Our Ref: R/52/20/HH
Your Ref:

Town & Country Planning Act 1990 (as amended)
Town & Country Planning (Development Management Procedure) (England) Order 2015
Application for Planning Permission for Works or Extension to a Dwelling

Development New garage
Location 32 Mill Lane Rustington

BLOCK PLAN

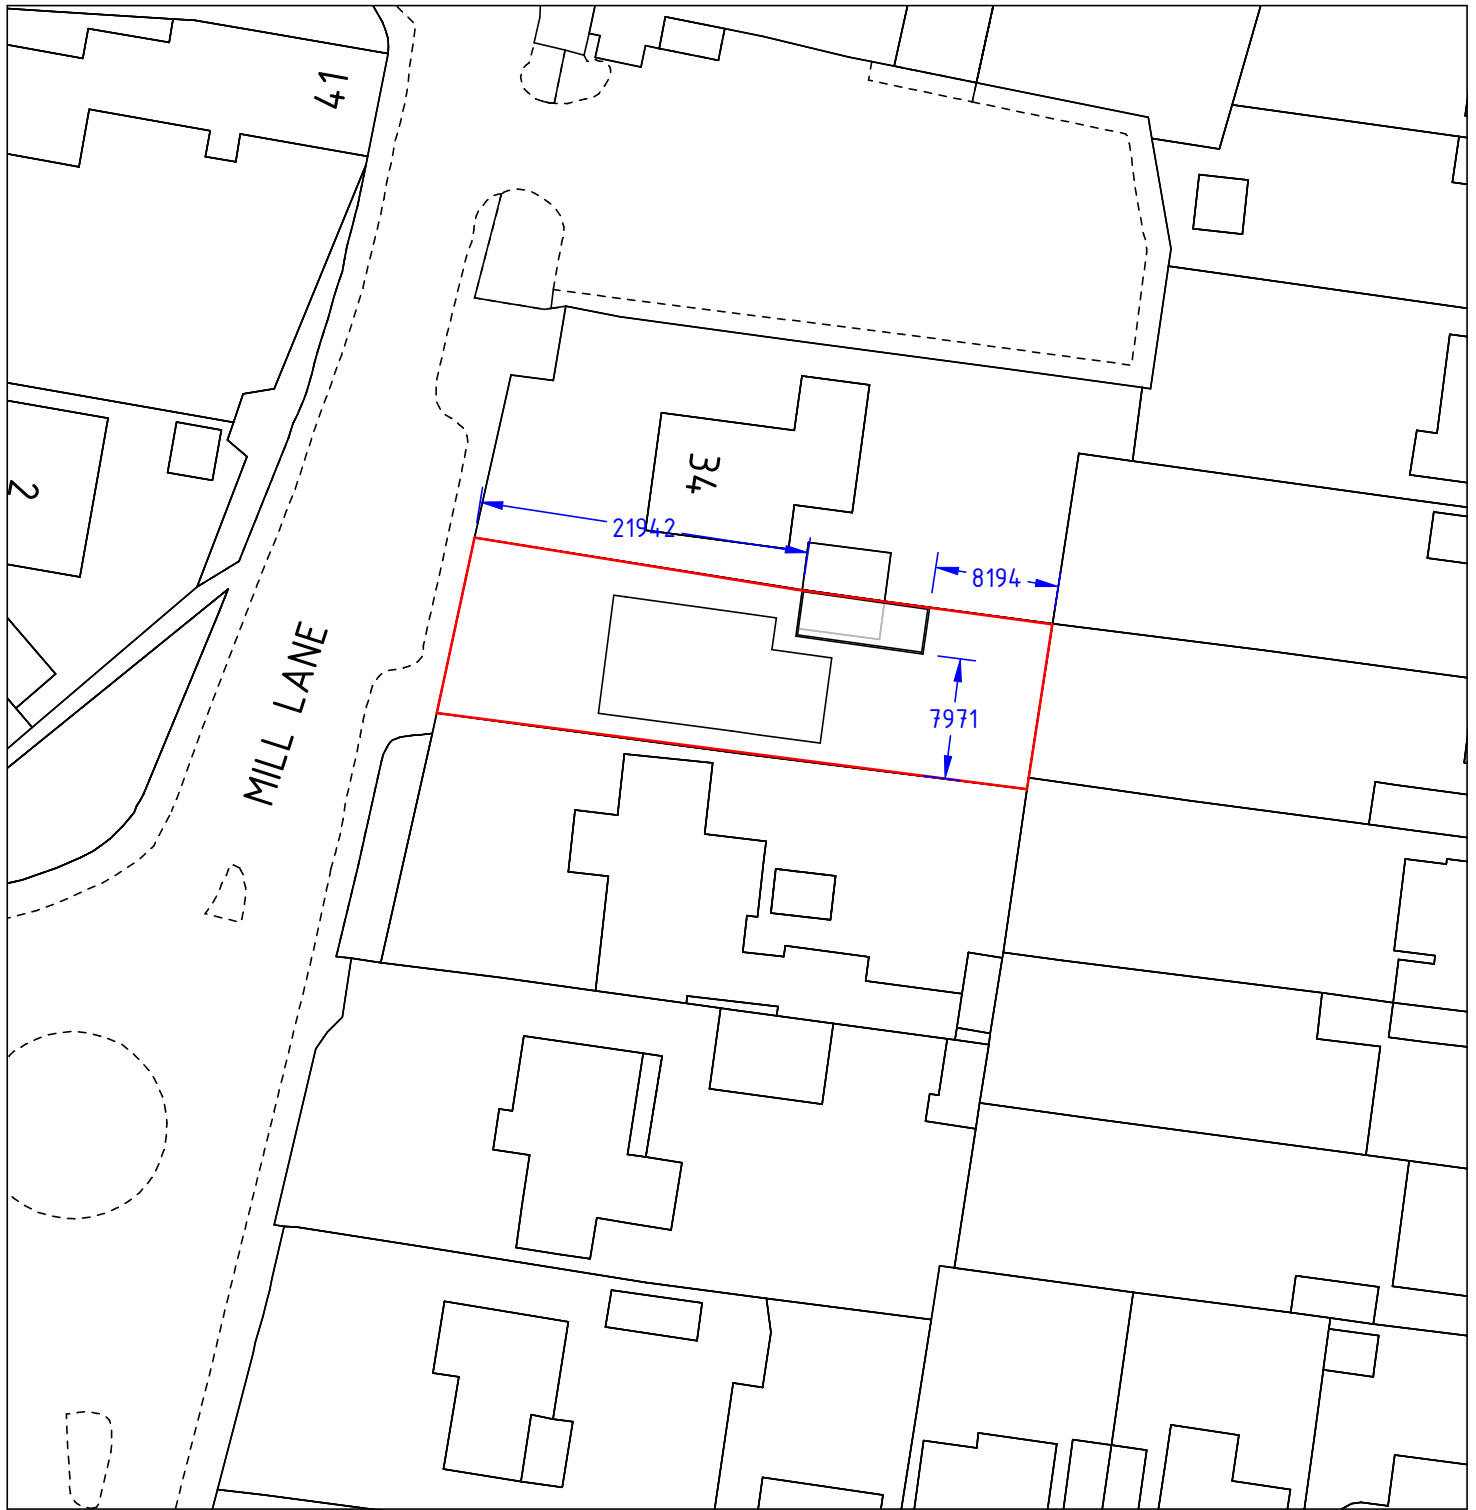
You are required to annotate the dimensions from all side of the proposal to the site boundary.

FLOOR PLAN
1:50

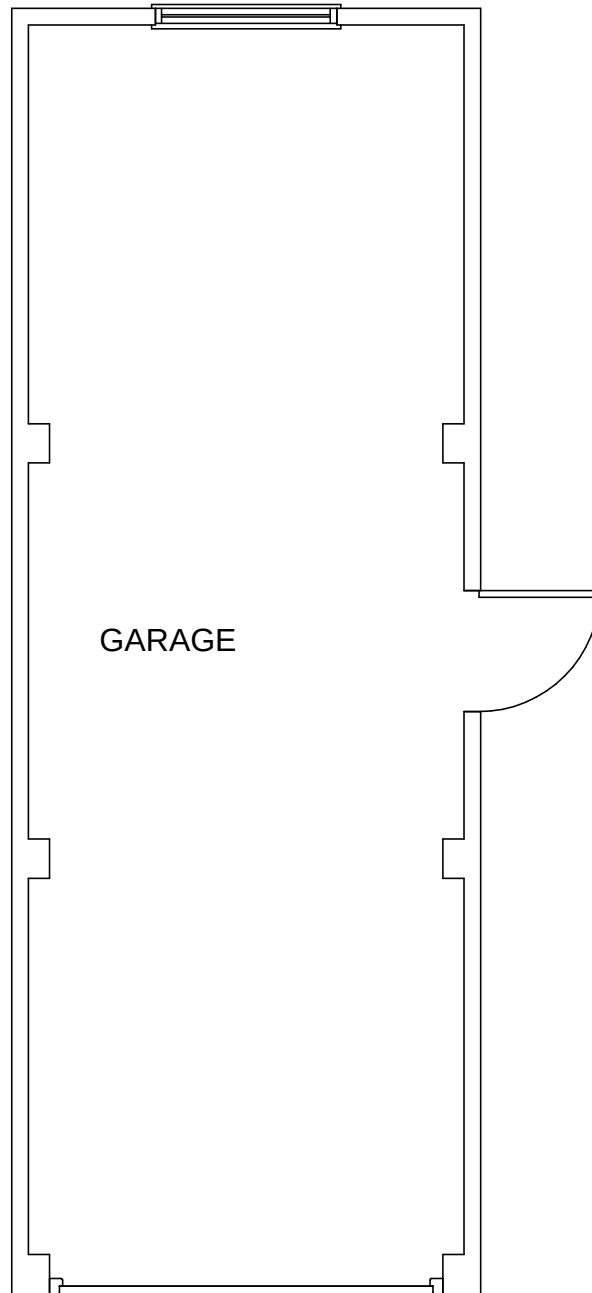
Please submit 1 electronic or 3 paper copies of clearly labelled proposed floor plans at a scale of 1:50 or 1:100. Further details can be found in the Validation Requirements List.
